Subject: RE: LU/134/21/PL & LU/135/21/L The Farm, East Street, Littlehampton

Martyn White
Principal Conservation Officer,
Planning Services

1. W10 Folder – These pictures are of the current porch for reference (W9) this is to be built as like for like as possible. If it truly going to be like for like it should be ok. Ideally, this would be confirmed with the relevant drawings

Drawing Name
Cellar, Ground Floor and First Floor Plans - Proposed

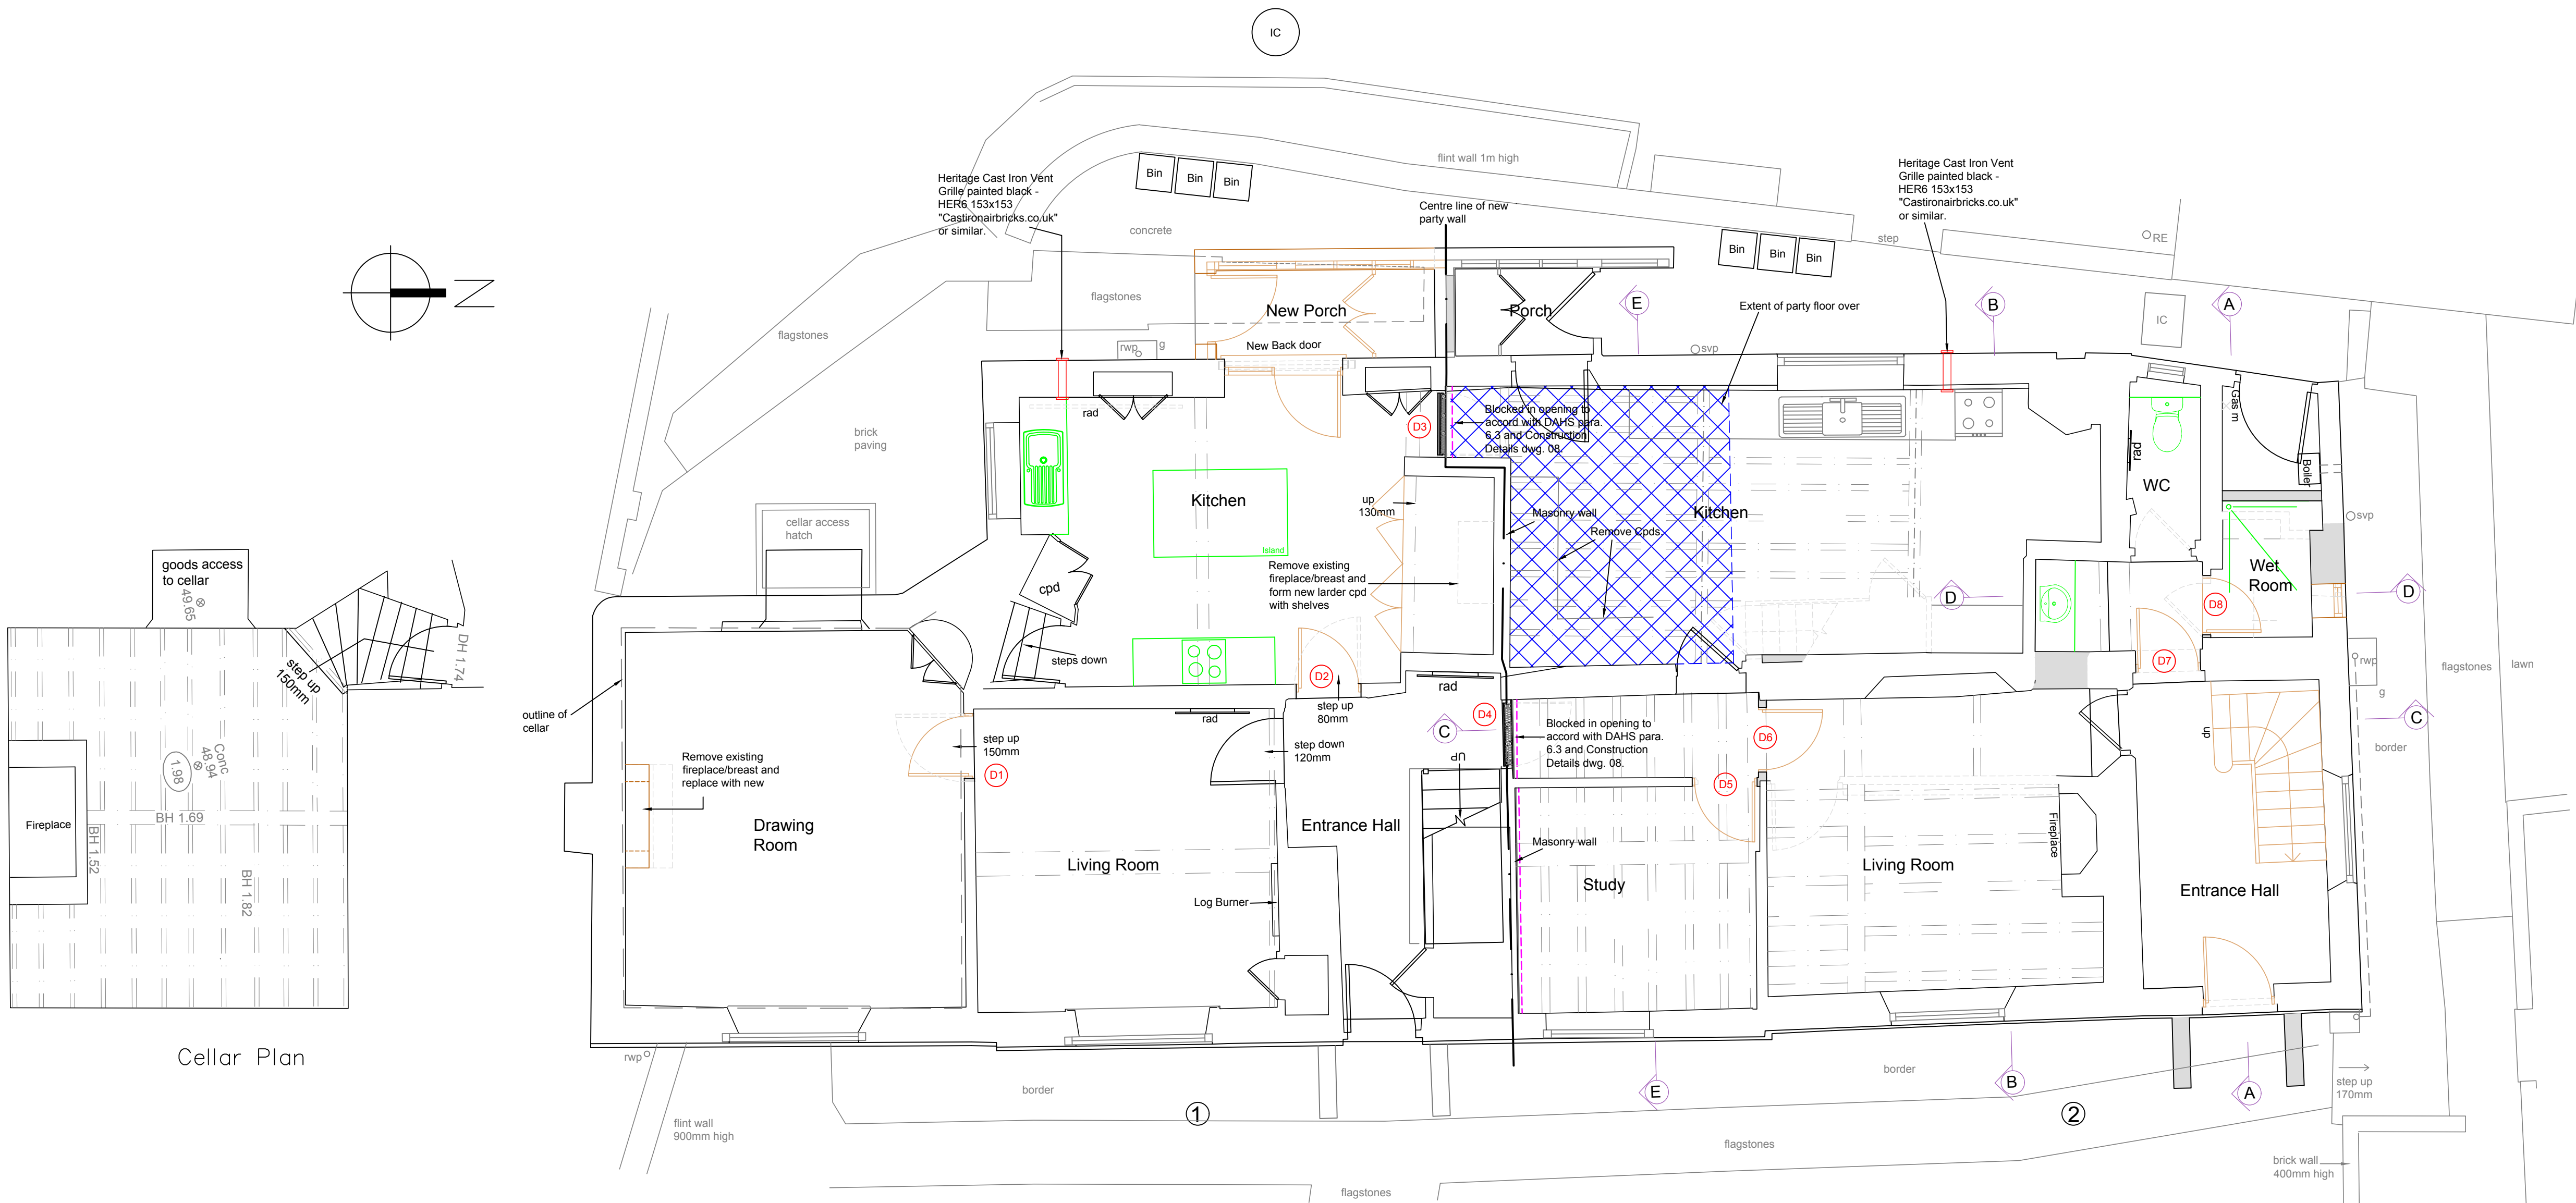
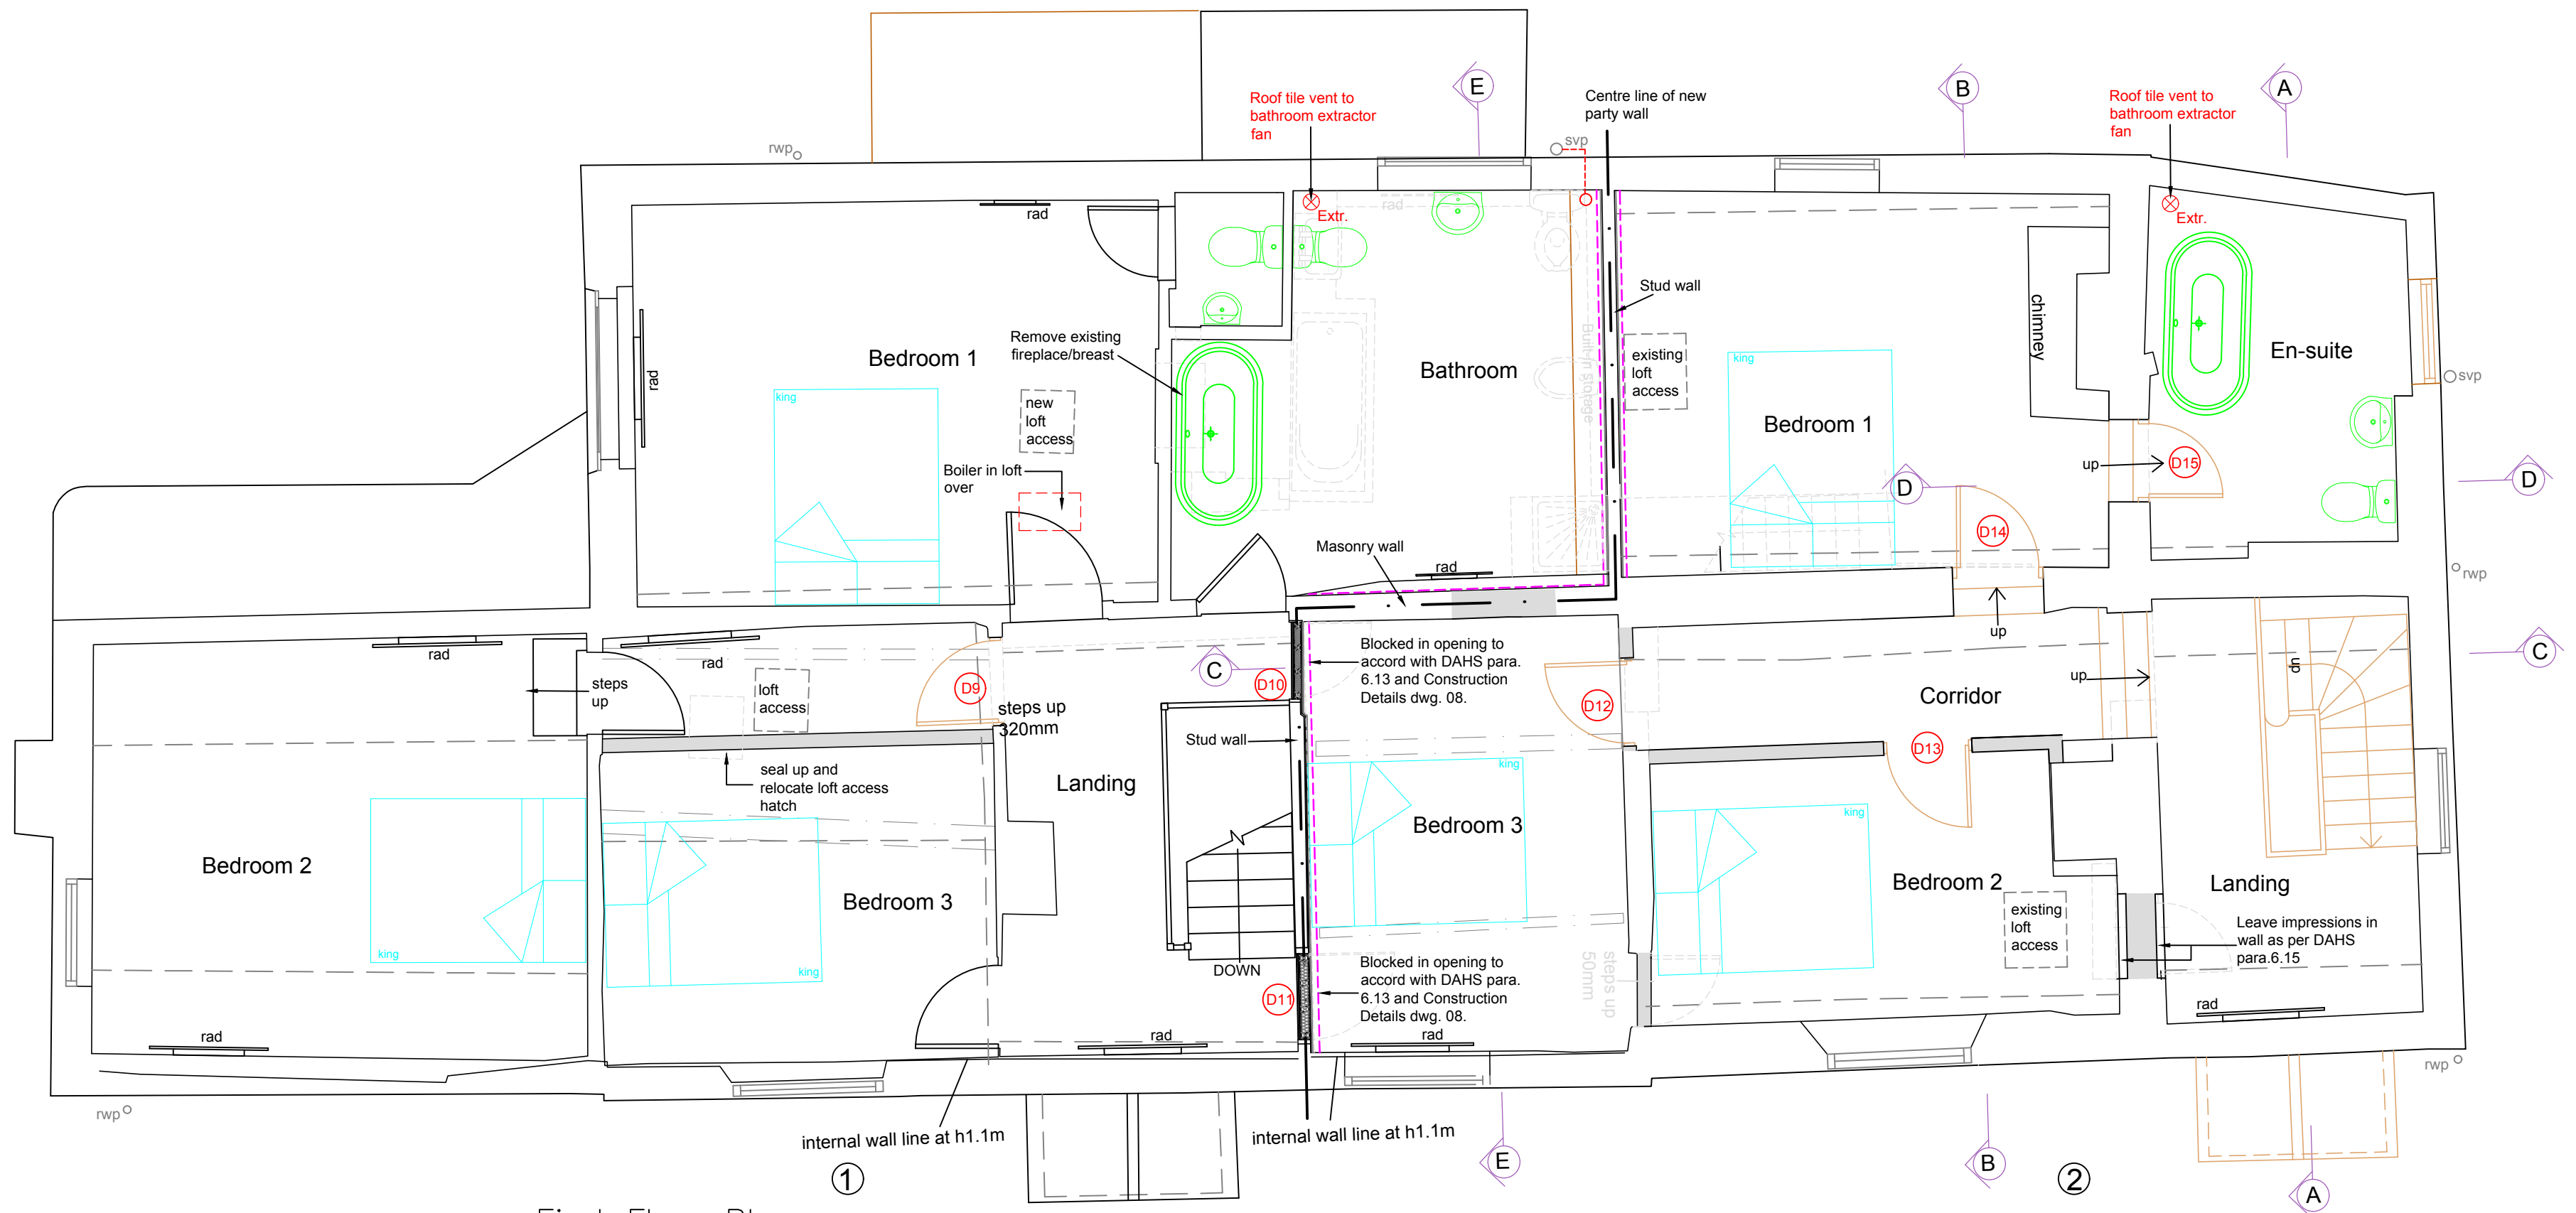
6. In regards to W1 there is no work to be done on this window. Noted.
7. In regards to the boundary treatment, the 1m picket fence will be put behind the wall, the side of the house not the street. This will have about half a meter of fence shown from the road if looking at the property behind the wall. This seems to be acceptable. Will it be stained, painted or left natural?

Drawing Name	Elevations - Proposed
--------------	--------------------------

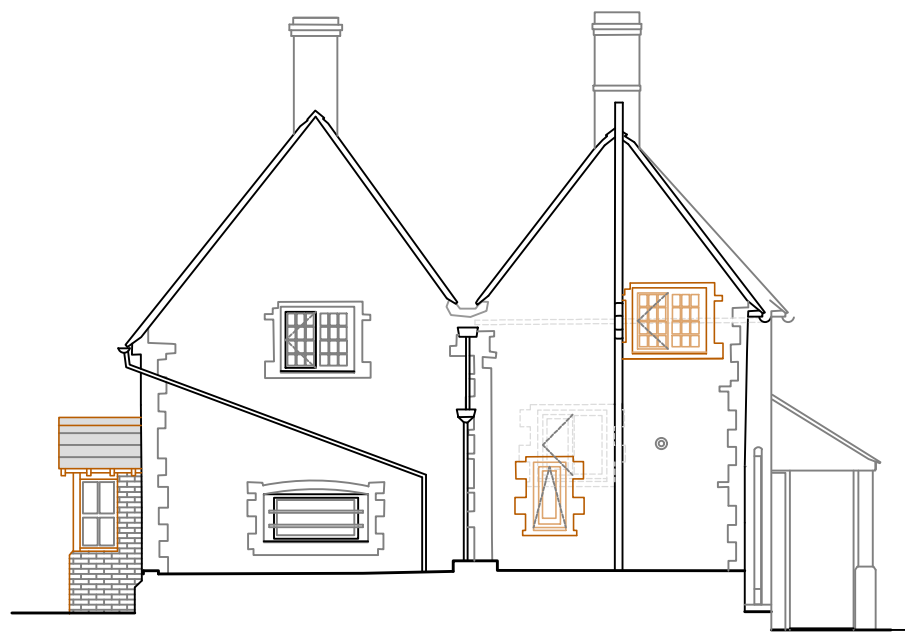
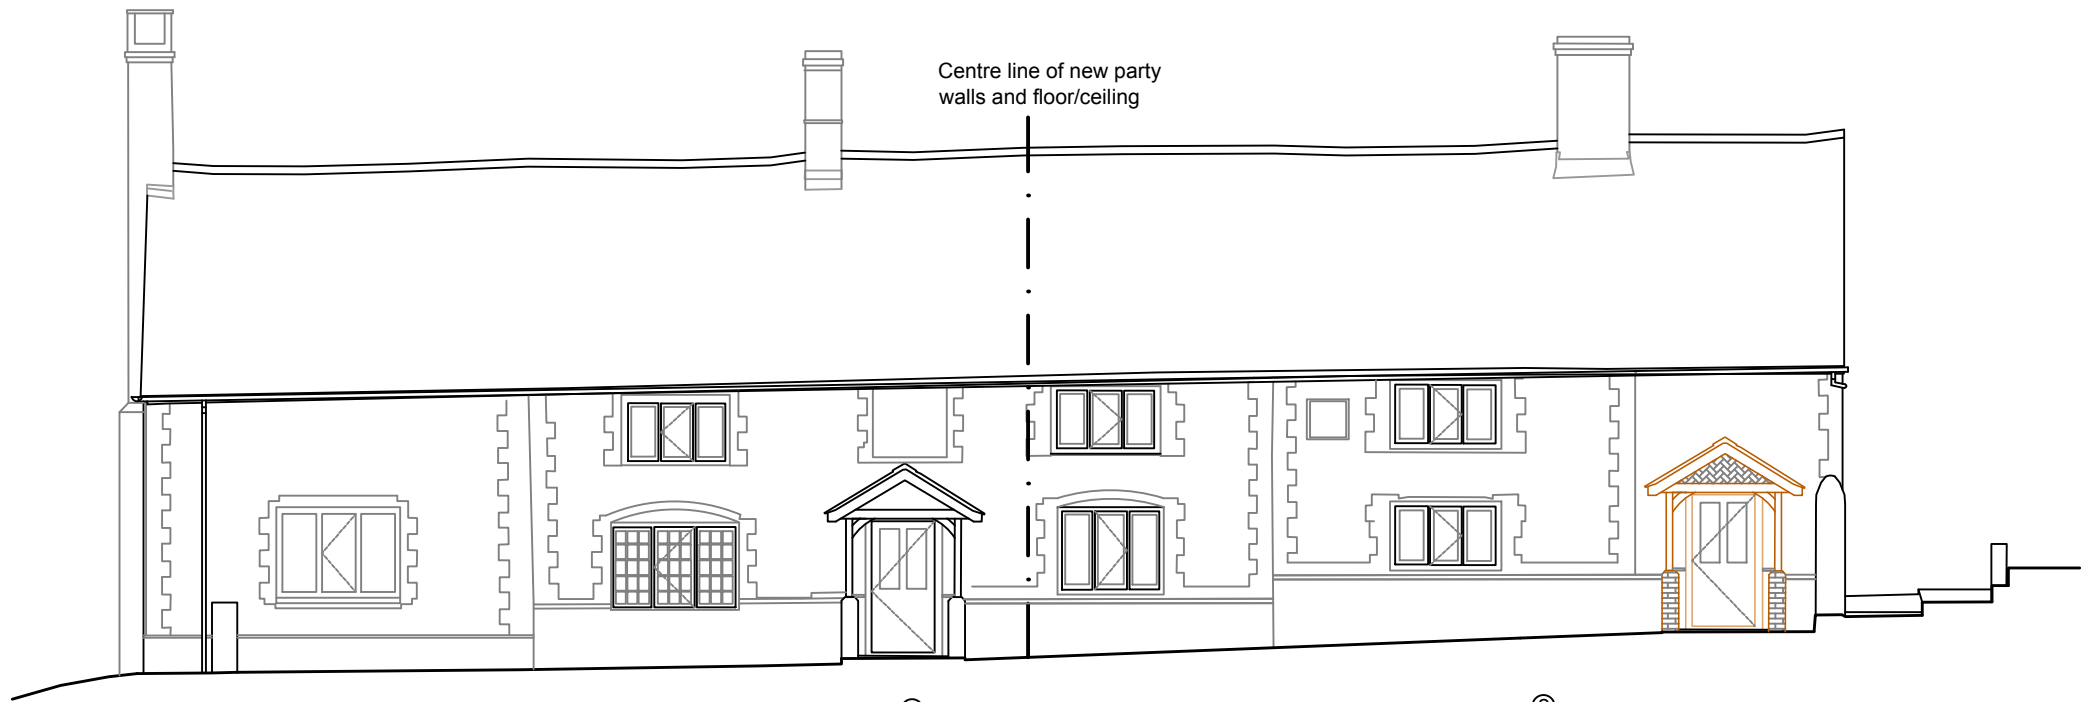
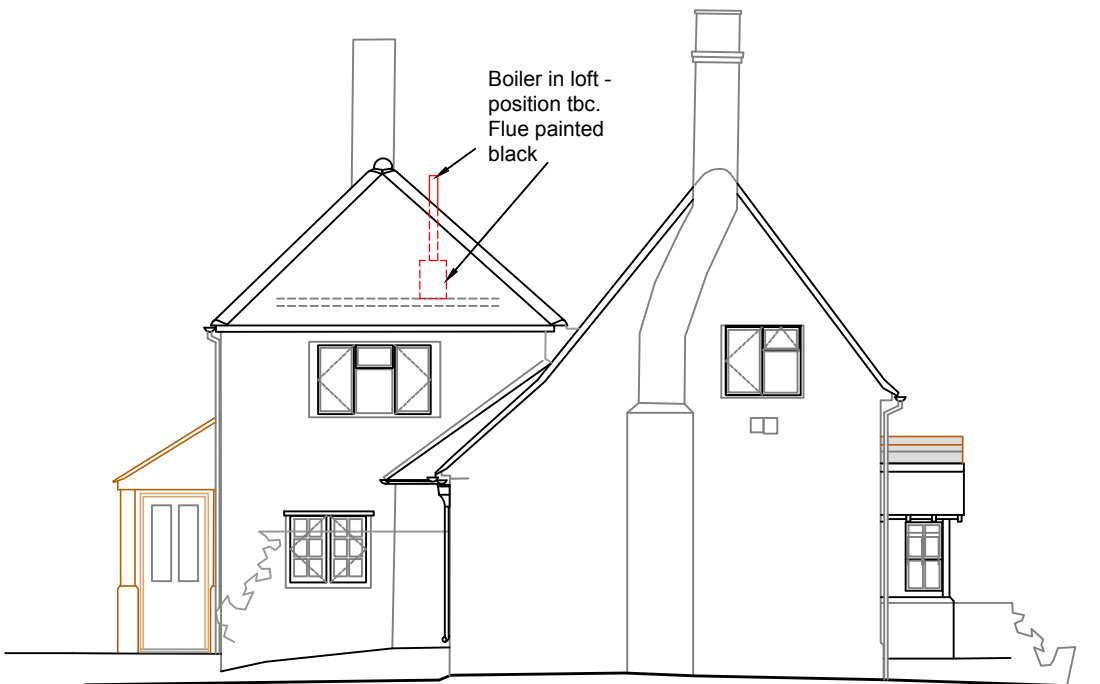
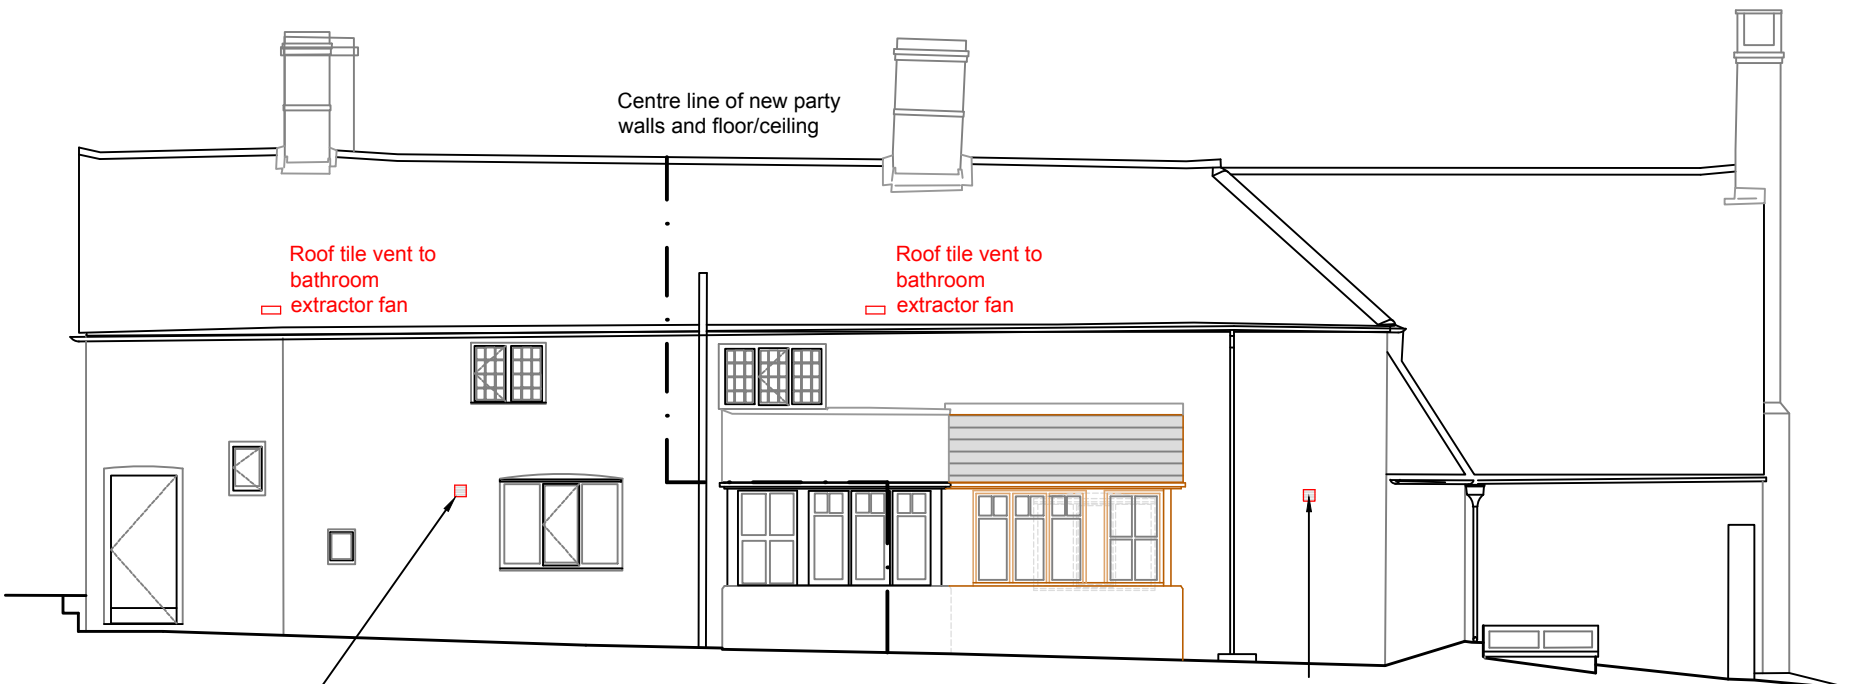
2. W6 Folder – This is the current GF wetroom window – needs to be removed and new top hung opaque window installed. Does this suffice or do we need to provide a sectional drawing? Ideally, yes. Would it be flush?

3. W16 – These pictures are of W15 for reference – this is to be like for like however not a Sussex pin window and will be a hinge window – picture of W13 for reference for hinged window. Does this suffice or do we need to provide a sectional drawing? We would want to make sure it is a suitable replica for the LB, and at present two photographs provided by the applicant show slightly different windows e.g. in one the glass is flush with the front of the frame, and in the other it is recessed. Which is correct?

4. ED6 (The Pic) – Sectional drawing to be forwarded – further information will be helpful as it is not possible to understand what the door and window will look like/be constructed from.

5. W11. – Not shown as to be replaced. On closer attention may need replacing like for like. Do we need to update the plan to reflect this? And if stated like for like will there need to be any further information to support this? Ultimately, we would need to understand what the replacement window will look like if it is needed. I personally would say that the easiest thing to do would be include it on the plans and then there is no need to request permission from us to replace it.
